**PLANNING DEPARTMENT
DEVELOPMENT SERVICES DIVISION
600 2nd Street NW, Ground Floor, 87102
P.O. Box 1293, Albuquerque, NM 87103
Office (505) 924-3946**

OFFICIAL NOTIFICATION OF DECISION

Project# PR-2020-003484
Application#
SD-2023-00048 – PRELIMINARY PLAT

For all or a portion of
**Lots 2 & 3, Block 12 Unit 3, VOLCANO
CLIFFS SUBD** zoned **R1-D** located on **Mojave
Street NW between Unser and Tesuque**
containing approximately **4.25** acre(s).
(L-10)

**MOJAVE SUBDIVISION**  
 GRADING AND DRAINAGE  
 GRADING PLAN

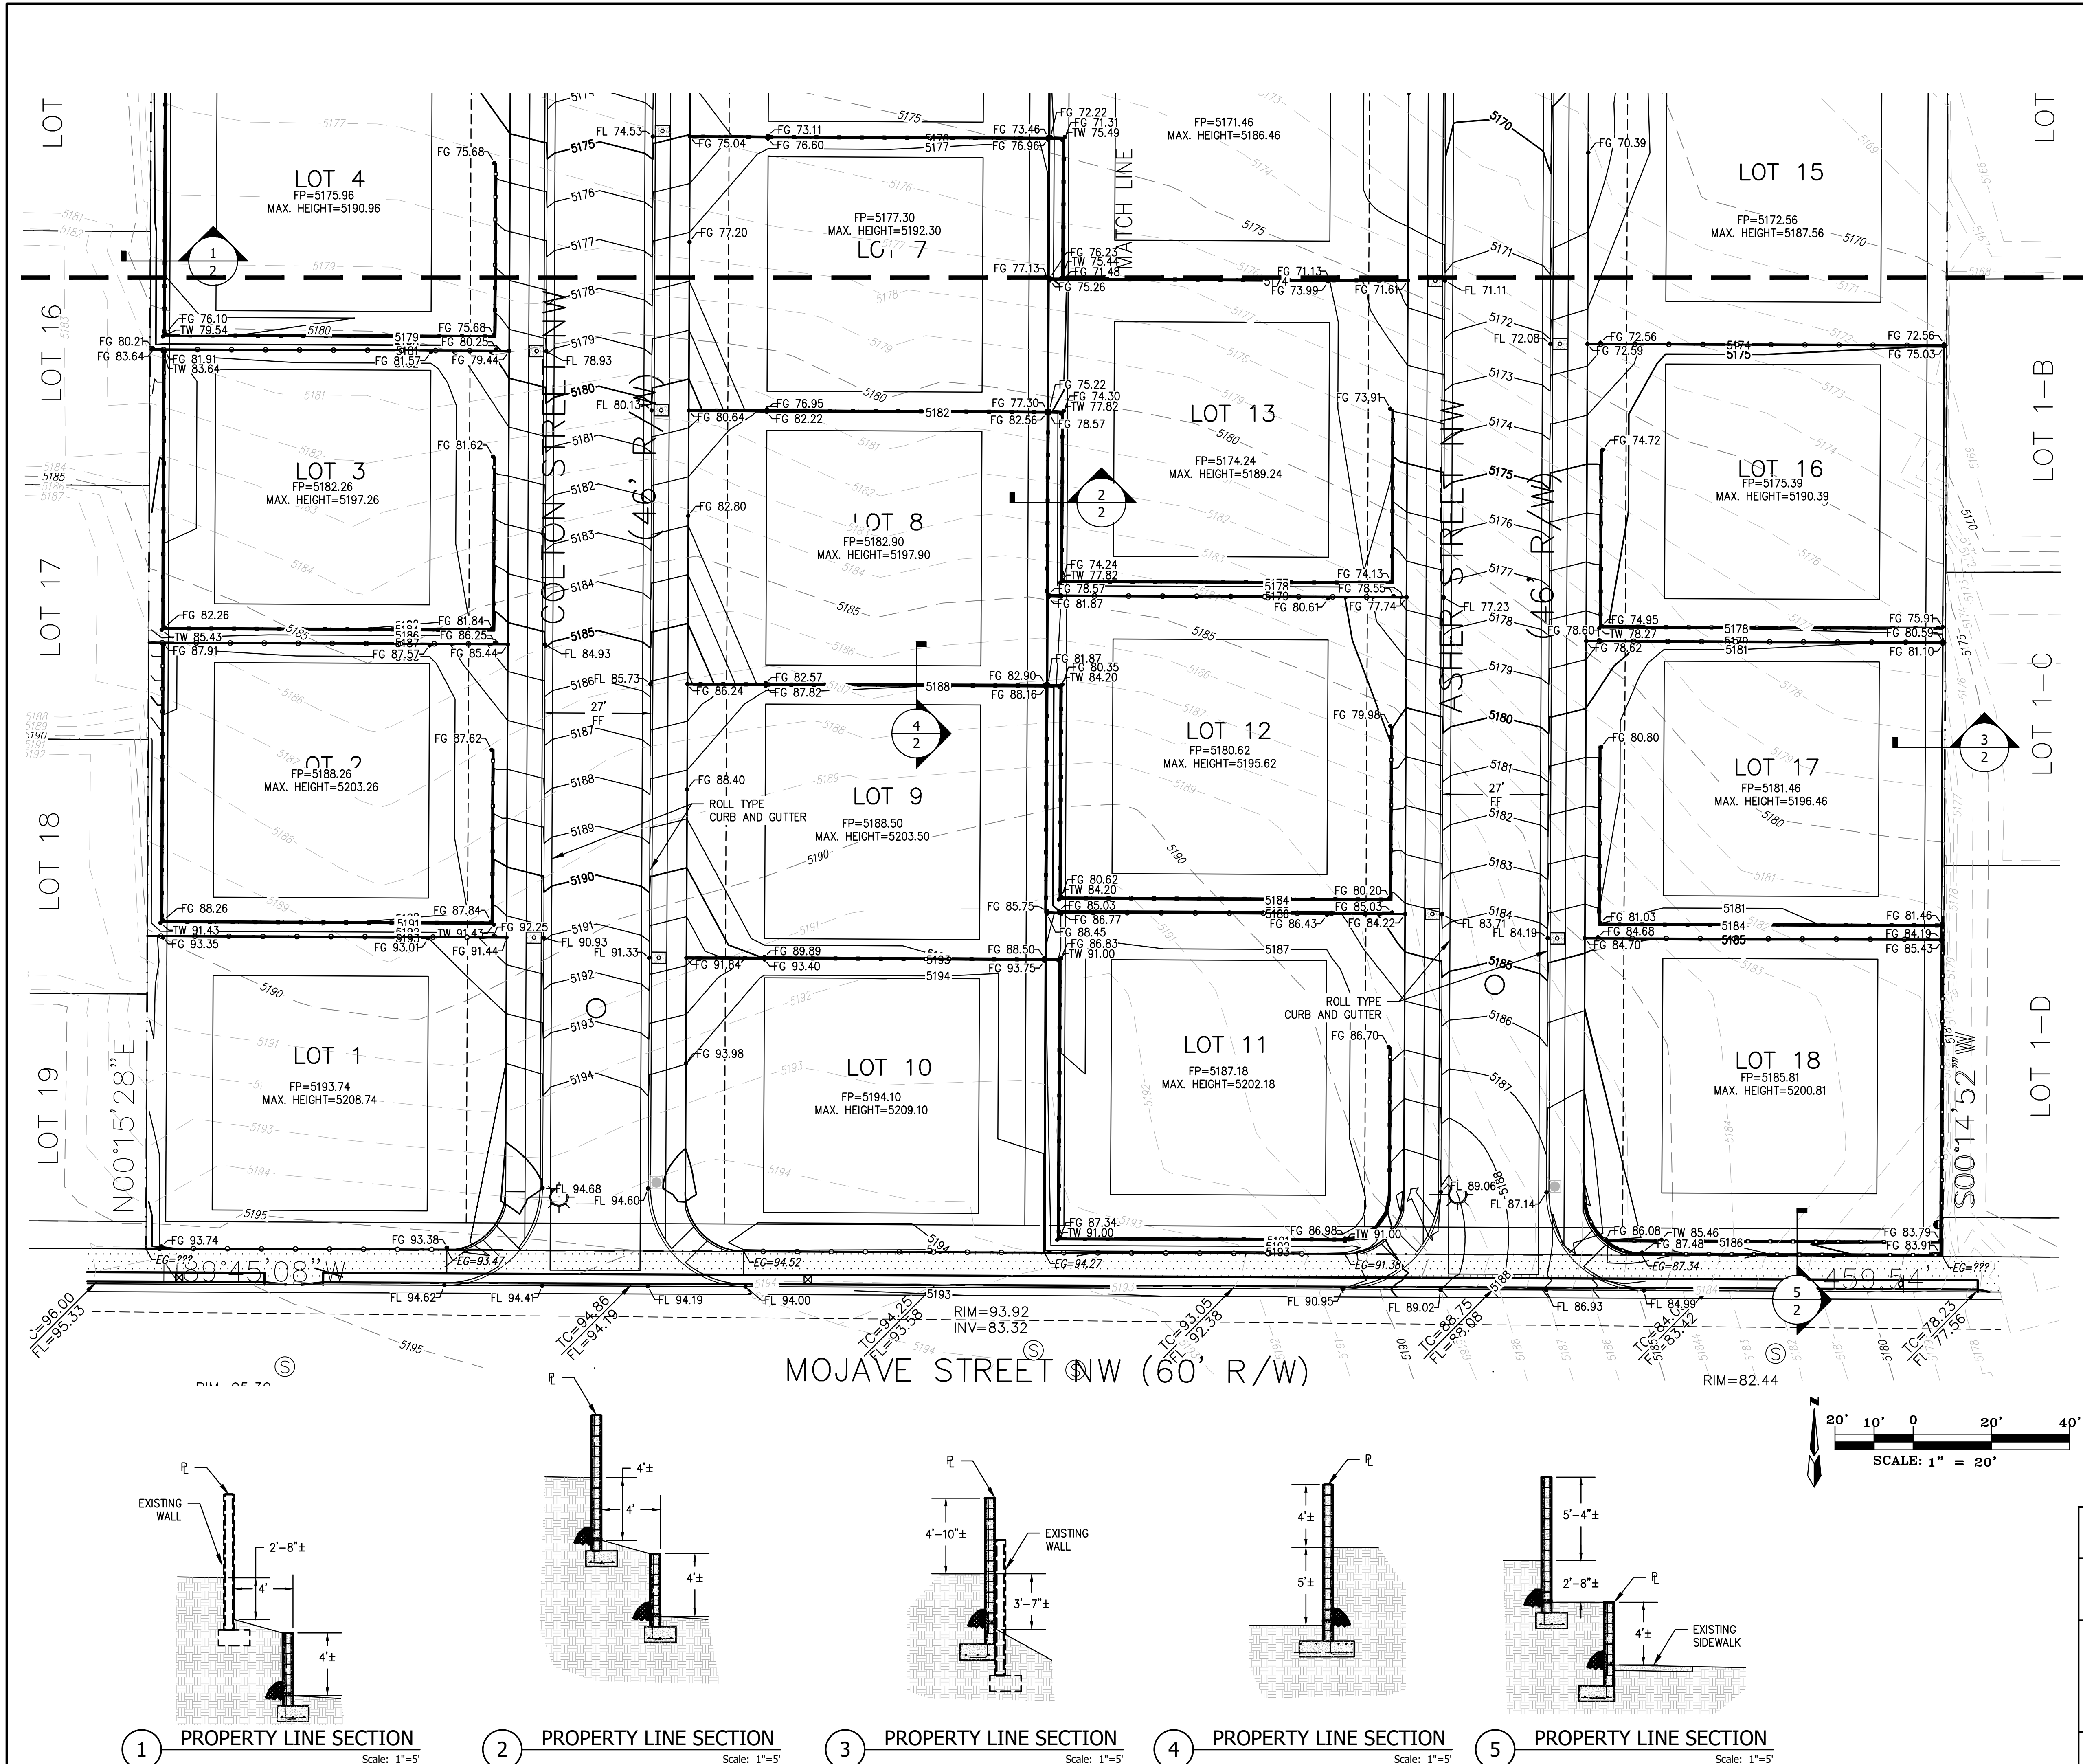
7. The Applicant will build a scour wall 6 feet away from the northern property line and on the private parcel to retain stormwater on site and protect the MPOS.

8. The grading plan complies with IDO 3-6(E) for parcels within the VPO-2 Height Restricted Sub Area, wherein, 'Building and/or structure height shall not exceed 15 feet, as measured from natural grade.' The Applicant has shown height measurements from finished grade and natural grade and established maximum building heights that do not exceed 15 feet.
